### **M3 Junction 9 Improvement Scheme – TR010055**

**Reference:** M3J9-EIA064

DRAWING TITLE
 FIGURE 7.4 - LANDSCAPE AND VISUAL: VIEW LOCATIONS
 APPF REGULATIONS 5(2)(a)
 DOCUMENT REFERENCE 6.2

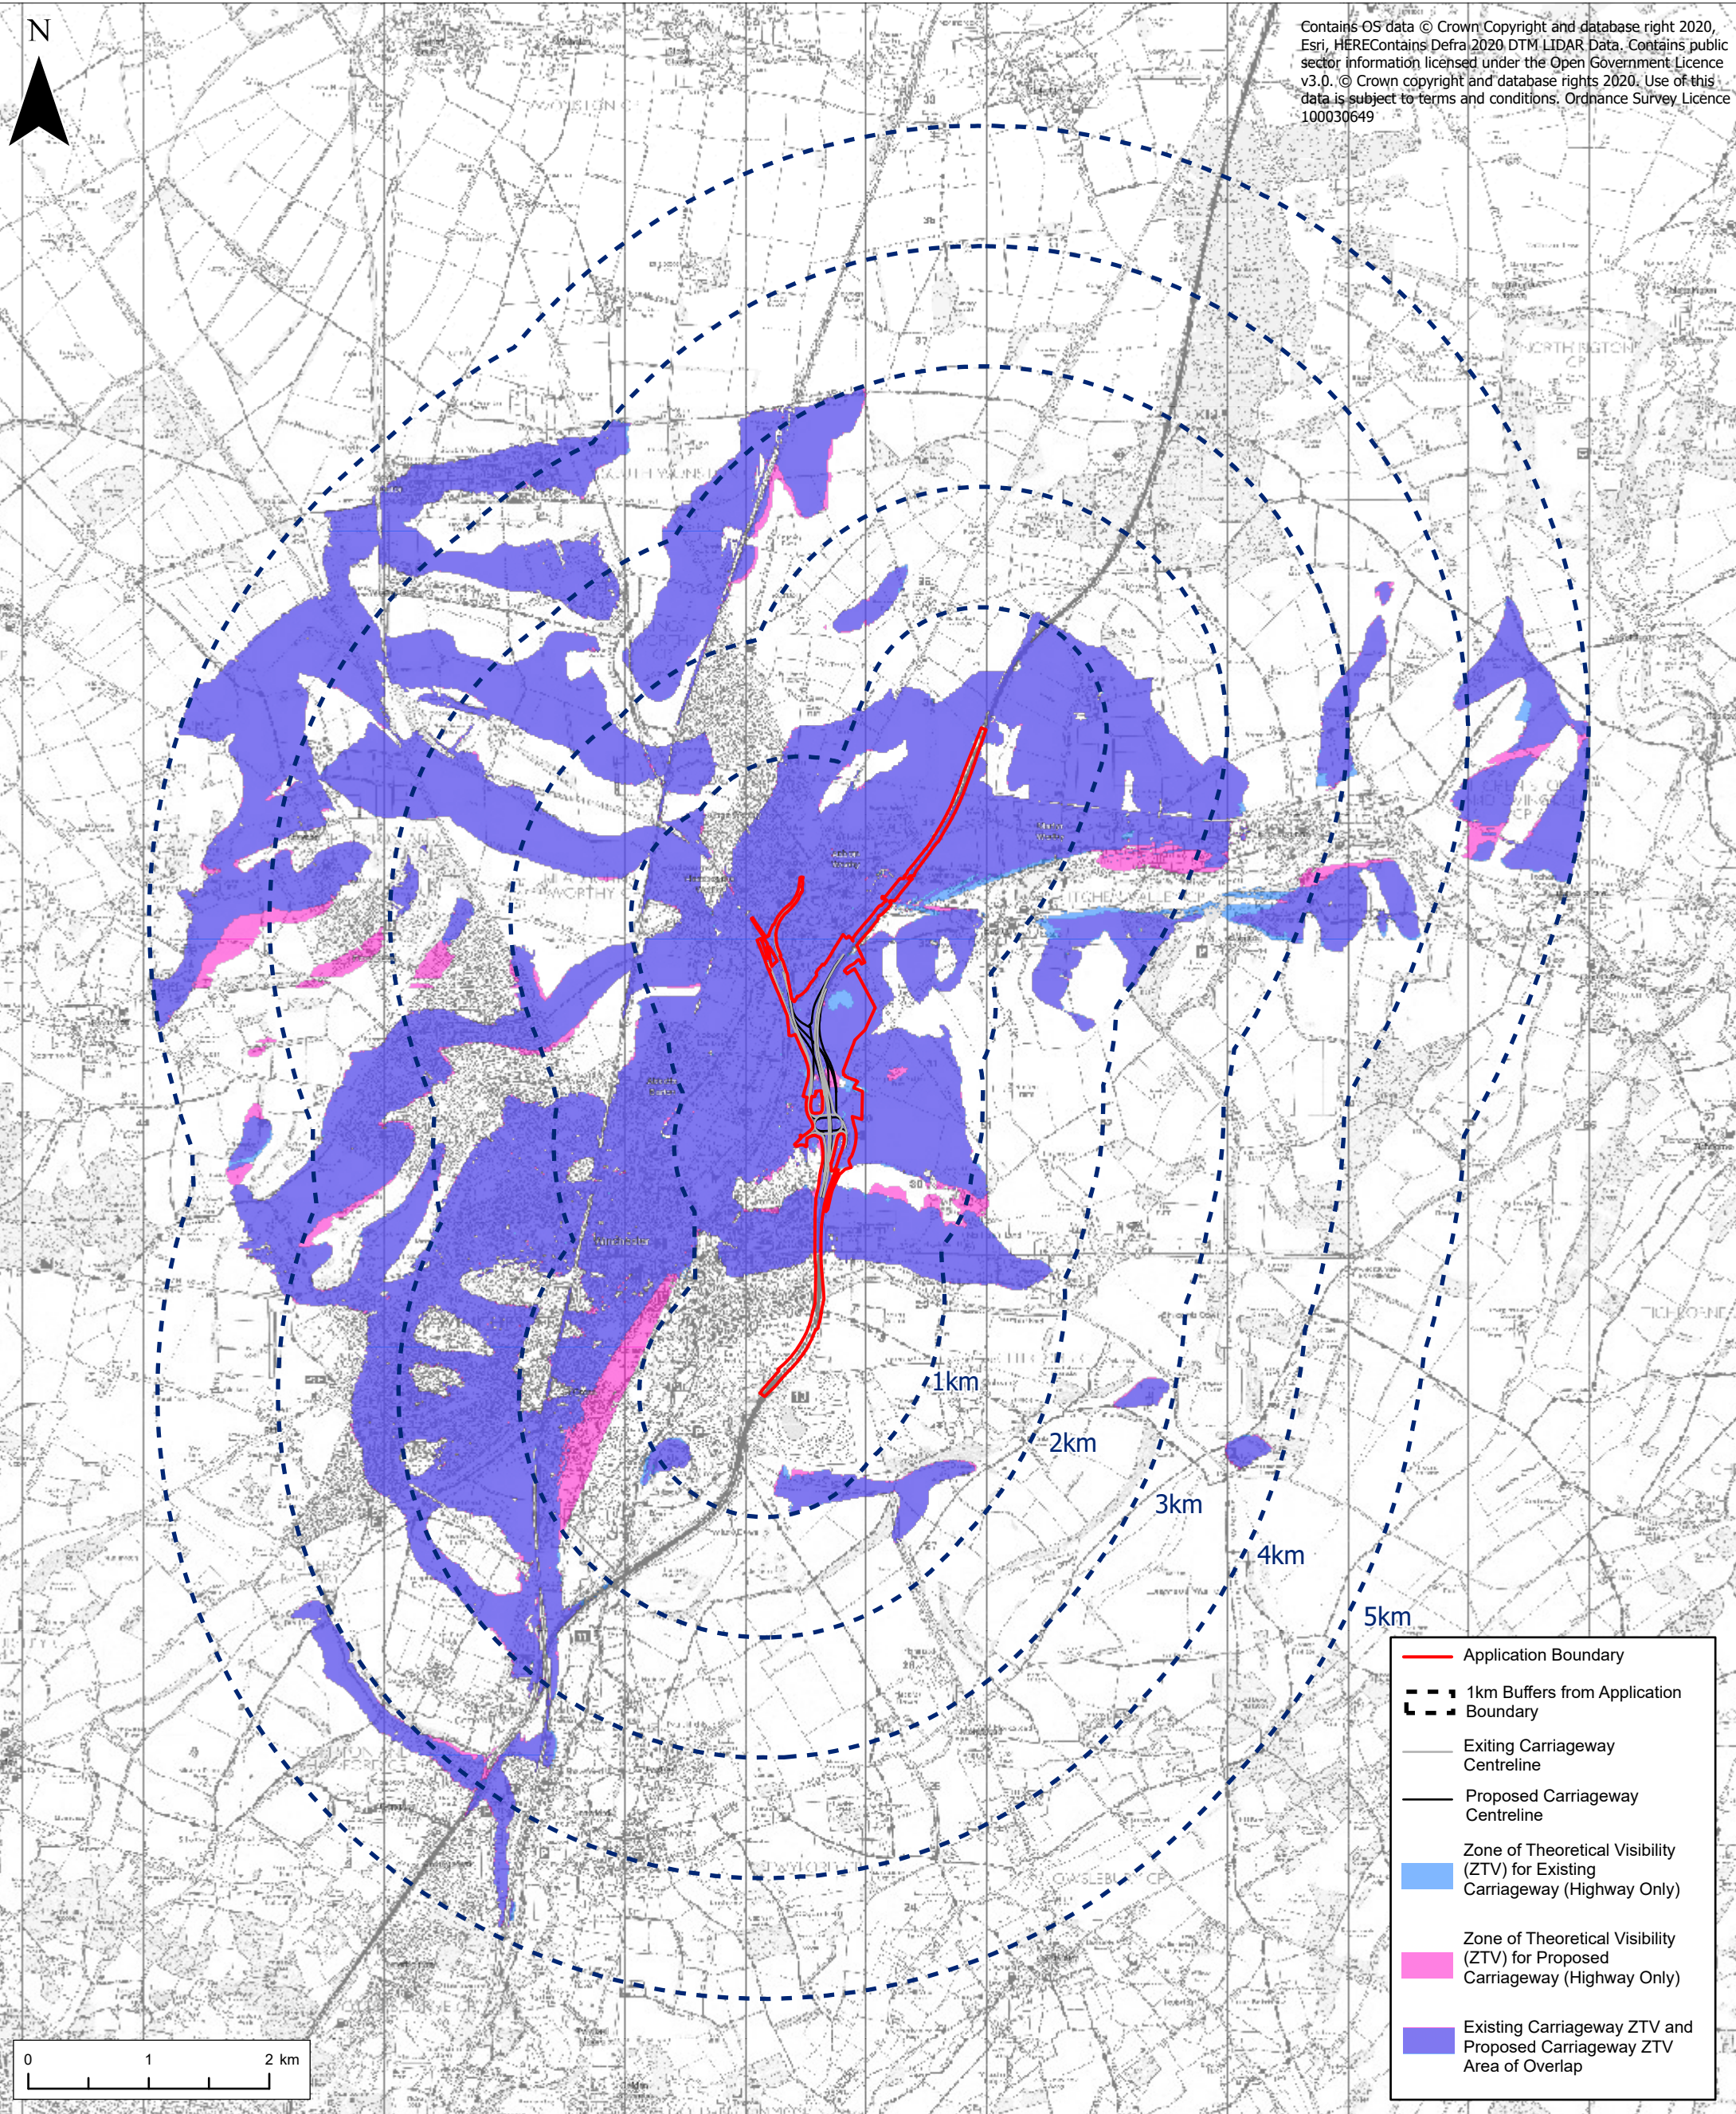
We note that the lighting assessment seems to be focused mainly on the permanently lit features within the scheme (the gantries and the lit underpasses) rather than on light from traffic on the newly created slip roads. From Viewpoints 1, 3 and 14, for example, it is the traffic on the newly created slip roads that are most likely to be visible. We await the revised visualisations from Viewpoint 3 to see if the lighting on the gantry on the M3 will also be visible at year 1 and during the winter at year 15.

With regard to the reasons set out in the Applicant's answer as to why they consider the long-term effects to be very small scale, we consider that views from the west, such as Viewpoint 3, are not currently affected by lighting within Winchester and that the permanent change from St Swithun's Way would be greater than 'very small scale'.

It is the SDNPA's position that the effects at Easton Lane (Viewpoint 1) would remain significant even after 15 years as there would be a complete change in landscape character from this viewpoint. We consider that the effect at winter year 15 would be moderate / major adverse. This is due to the need to accommodate two new slip roads and an attenuation basin in this area which will require substantial changes to the
